POST-EPC MEMORANDUM

RE: Paradise RV Park (formerly West Mesa RV Park)

Project #1008830/11EPC-40073 – Site Development Plan for Building Permit

A-01

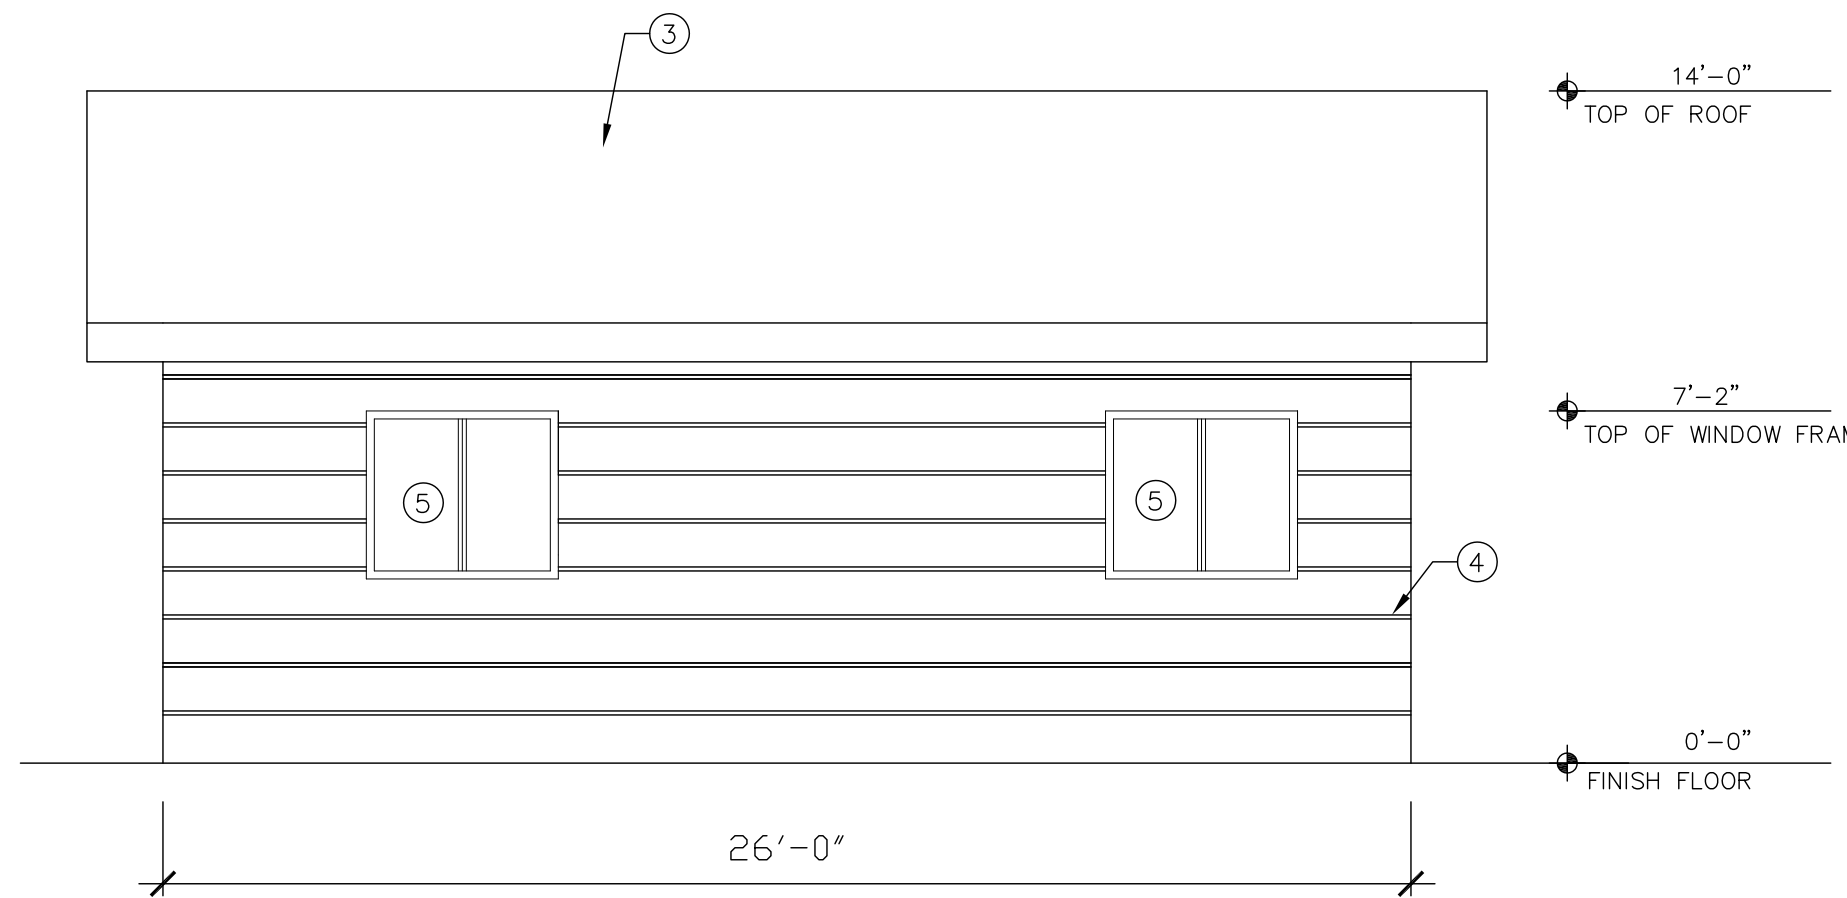
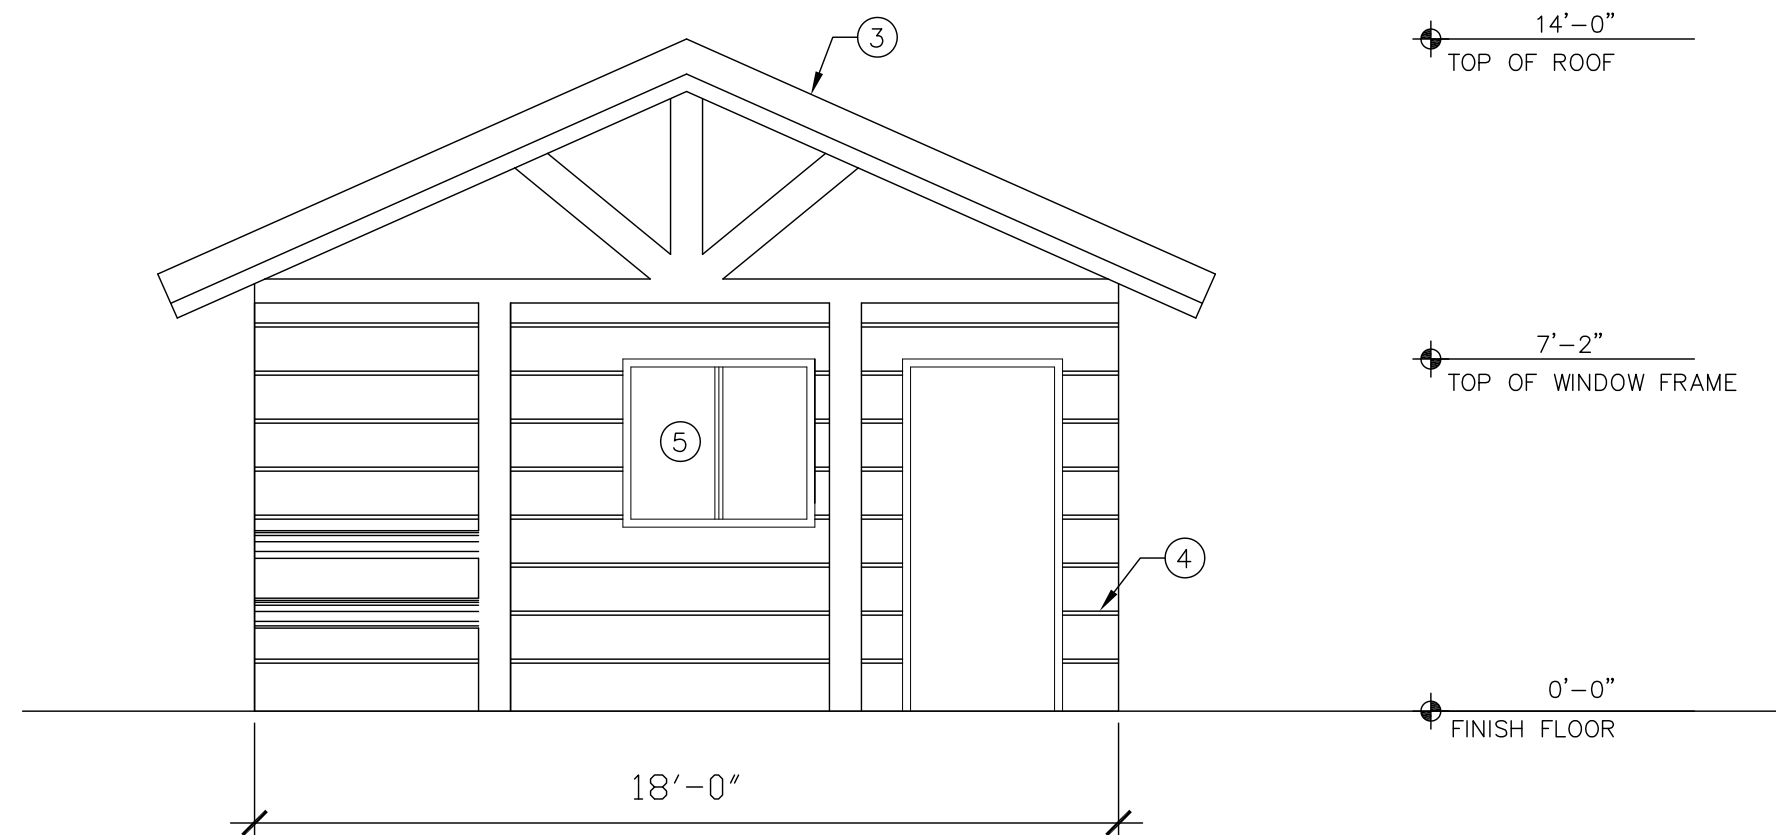
6. Condition 6 has partially been satisfied. The Lodge has all four elevations and window detail shown with dimensions on Sheet A-02. Sheet A-01, Log Cabins Elevations, are missing two elevations and window details. Submit the Log Cabin Elevation on Sheet A-01 with all four elevations with dimensions. Provide Log Cabin window details, including all dimensions on a detail sheet. Provide Log Cabin and Lodge door details with dimensions on a detail sheet.
